Date: 07/09/2025

Re: **Footing Projection Issue**
Location: Lot 50 Magnolia Ridge (Lillington, NC)
JDS Project No.: RDU2507094
Date of Inspection: N/A

STEM WALL DETAILS

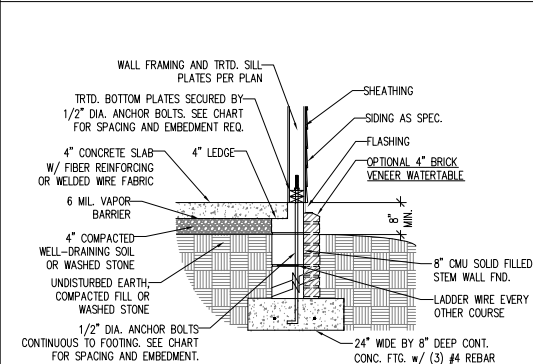
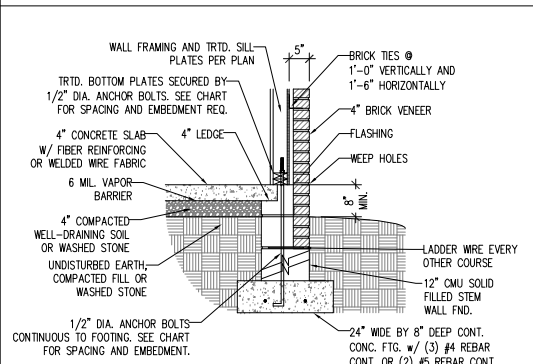
Client provided pictures of the foundation overhanging the footing/lacking projection on the exterior walls.

Based on our review of the client provided pictures, excavate down to the bottom of the footing and extend the footing 8" wide and the full depth of the existing footing. Dowell and epoxy #4 rebar spaced 12" o.c., minimum (2) #4 on each wall 4" into the existing footing extending 5" into the repair. Contractor shall use 2 part structural epoxy and ensure holes are cleaned with compressed air or a wire brush prior to injecting.
